Our Reference: SYD18/01322/02 (A28132282)
DP&E Ref: SSD 9522

Notice of Exhibition – Kemps Creek Warehouse, Logistics and Industrial Facilities Hub (SSD 9522)

DRAWING NUMBER ISSUE
SP-KC1-DA-003 I

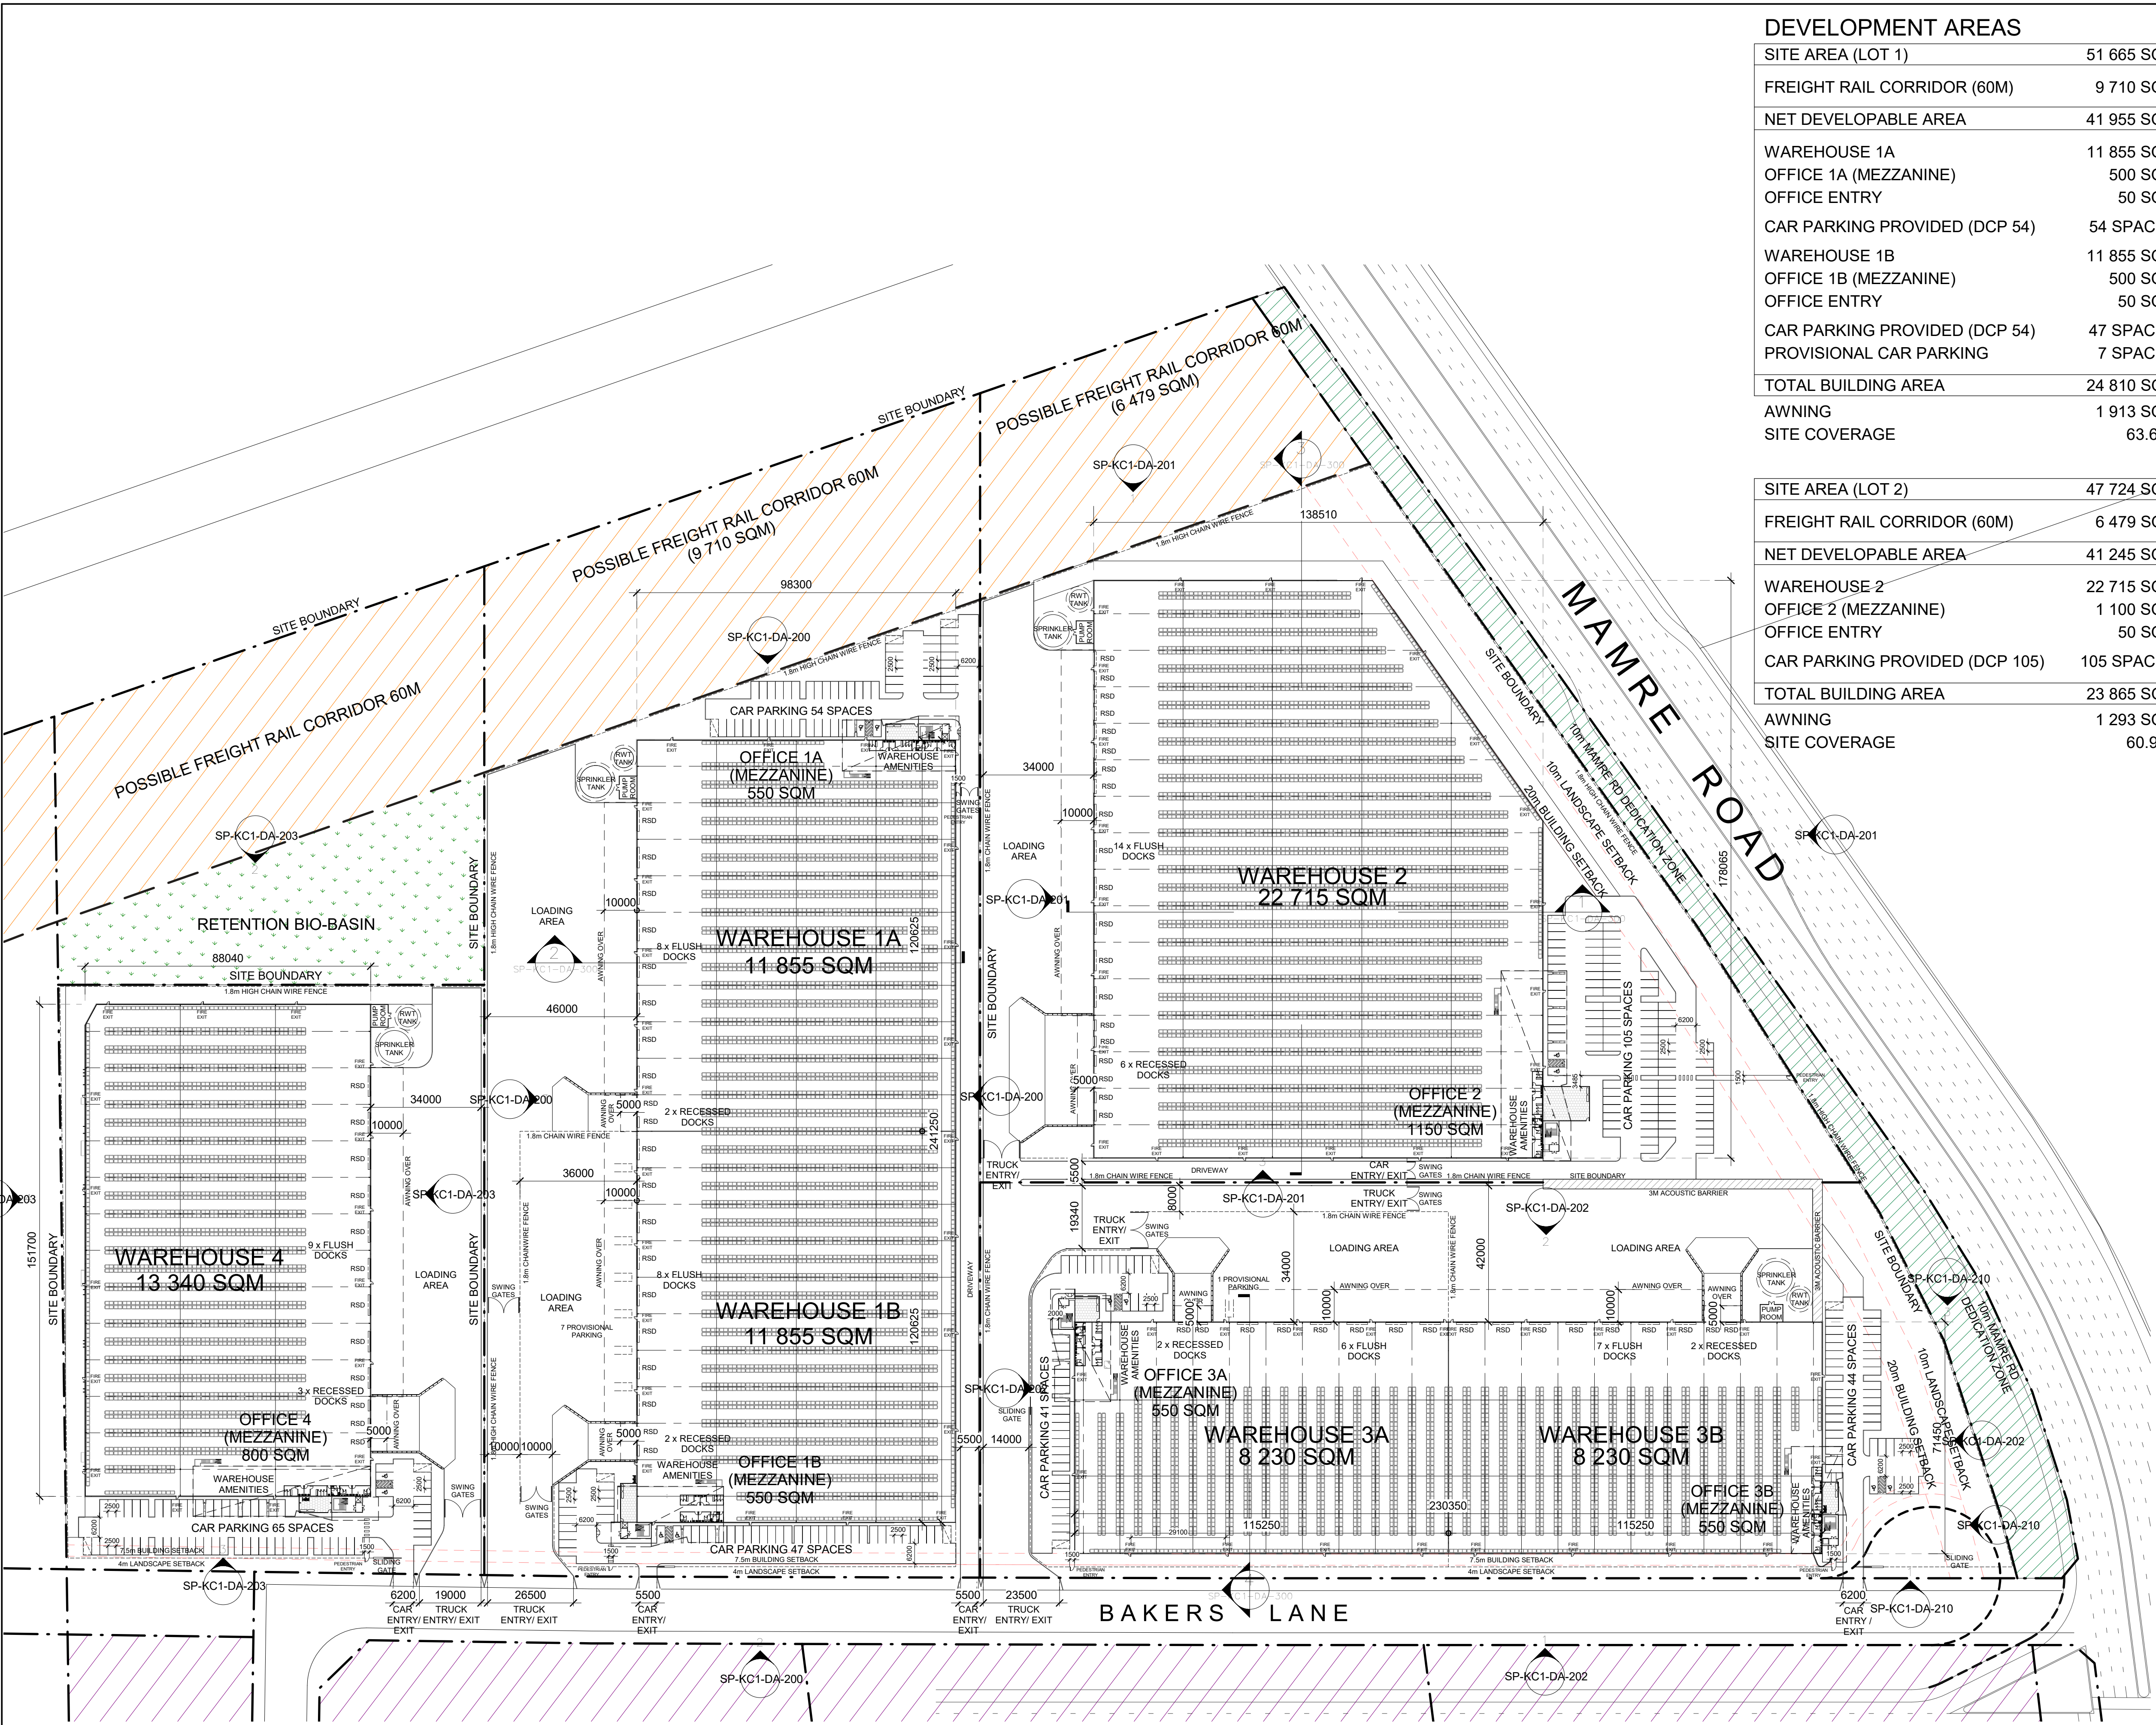
1. The proposed left in / left out on Mamre Road is not supported and all access must be from the signalised intersection with Bakers Lane.
2. A connection from the local road to the south must be provided to give access to future development.
3. The proposal assumed that Southern Link Road would be extended and the intersection of Bakers Lane/Mamre Road would be closed. However, the current strategic development of Southern Link Road only extends to Mamre Road.

All roads, signalised intersections and driveway cross overs are to be designed to cater for the swept path of B-doubles and semi-trailers.
